Application Number: S6/2010/0932/FP

We would like to register our concerns and objections to the proposed development at 42 Daffodil Close.

PROPOSED GROUND FLOOR PLAN

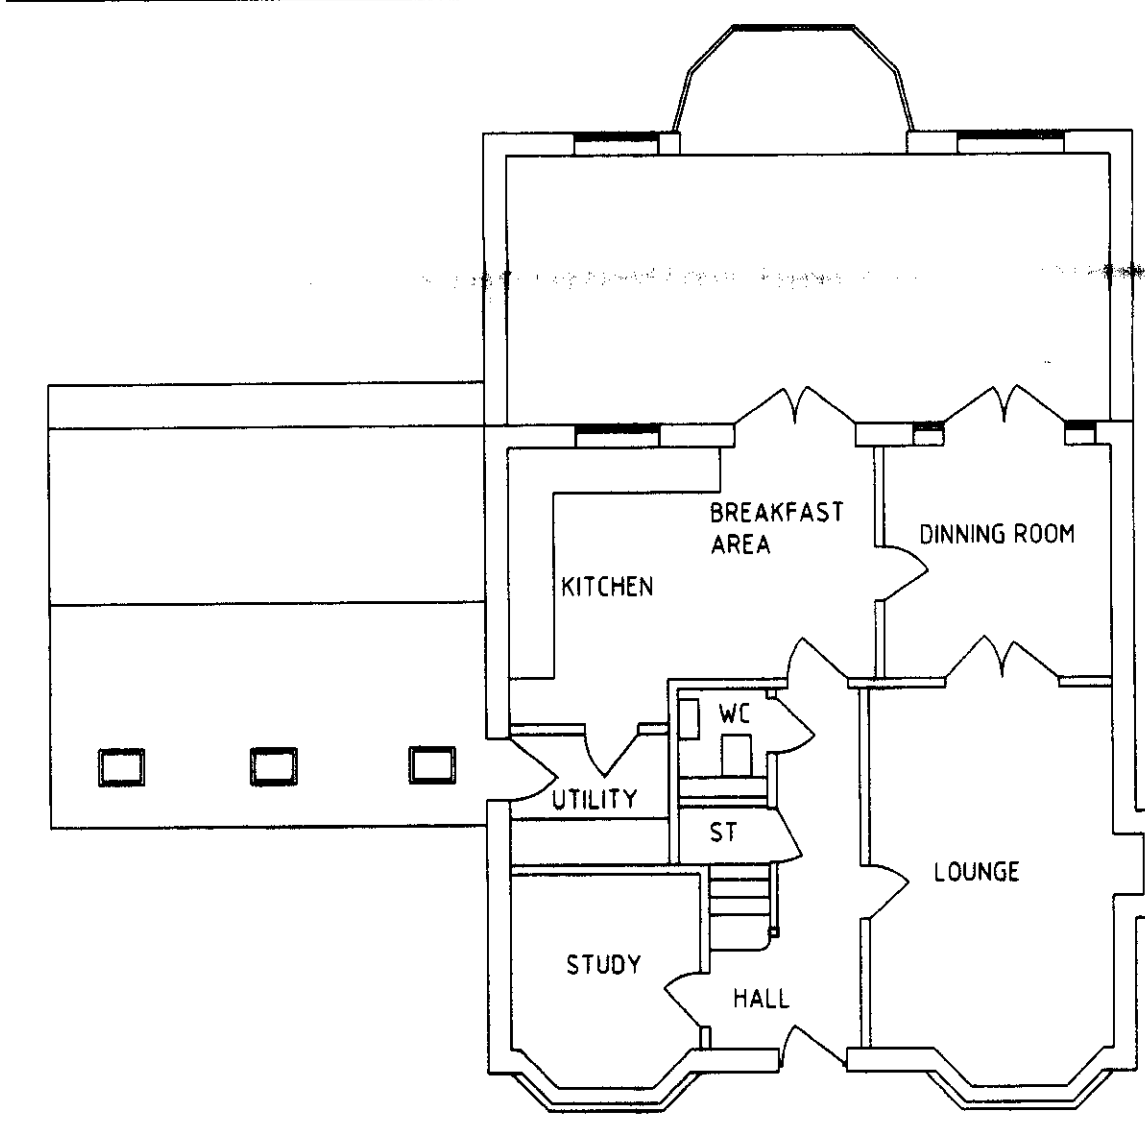
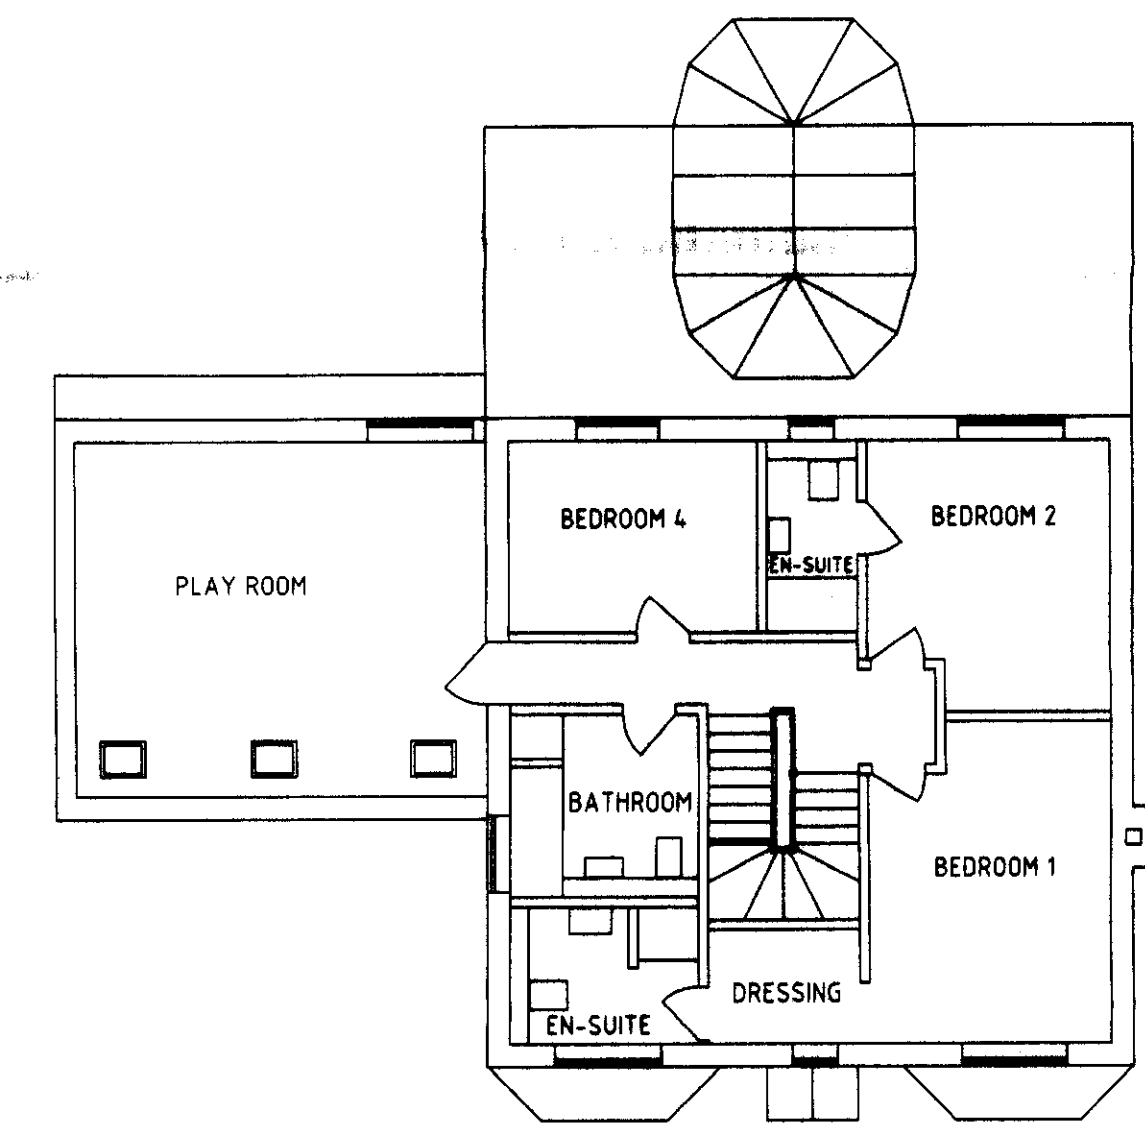
The proposed rear single storey extension with conservatory is far too large for the size of the property and the plot. This would bring the property much nearer to our boundary, closing in on our leisure space and be detrimental to the enjoyment of our property. This extension would dominate our outlook especially in the winter when there are no leaves on the trees. We feel this constitutes overdevelopment of the property and would dominate ours and the surrounding properties.

PROPOSED SIDE ELEVATION

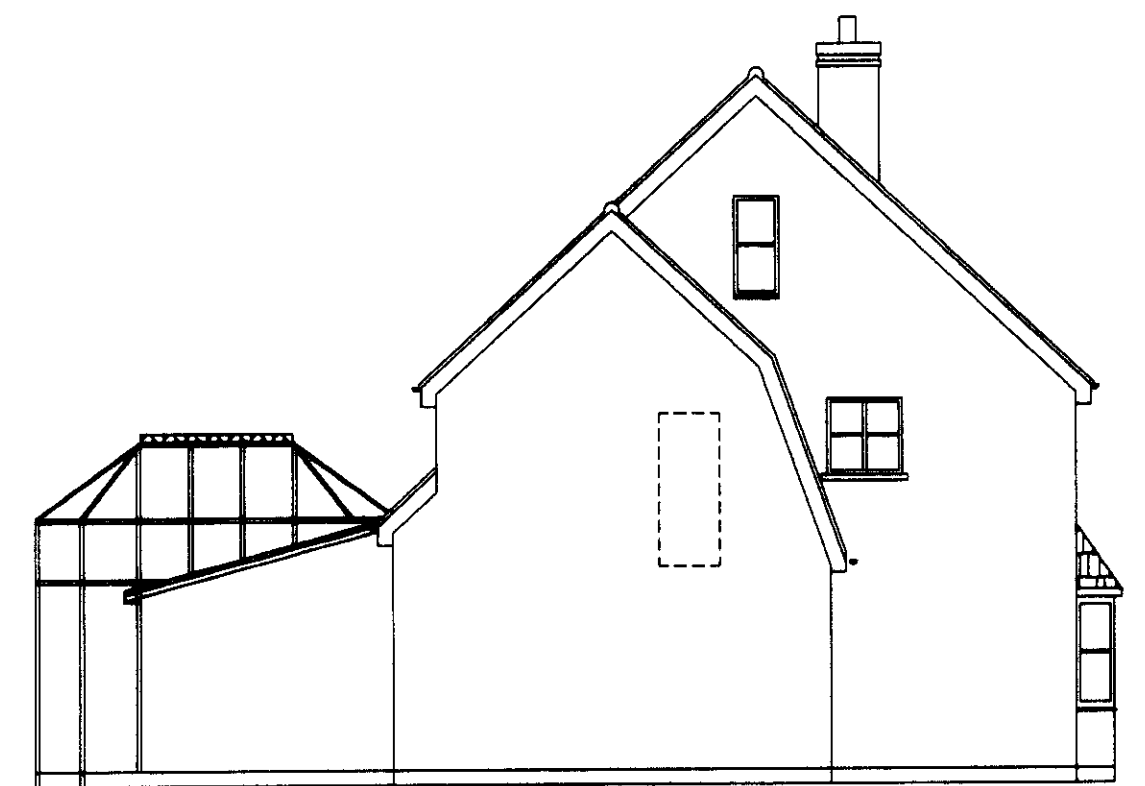
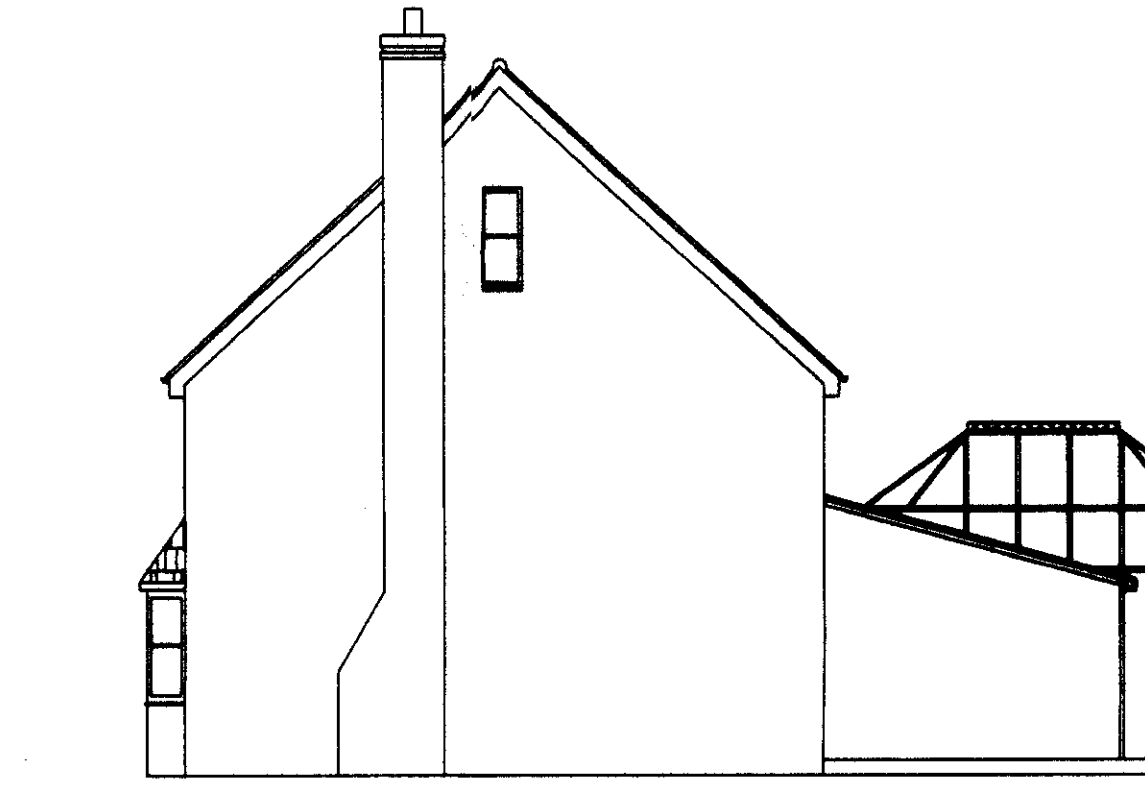
The proposed raising of the roof height above the double garage to provide a play room would make the property too large and overdeveloped for the plot whilst cutting out any suggestion of openness from our perspective.
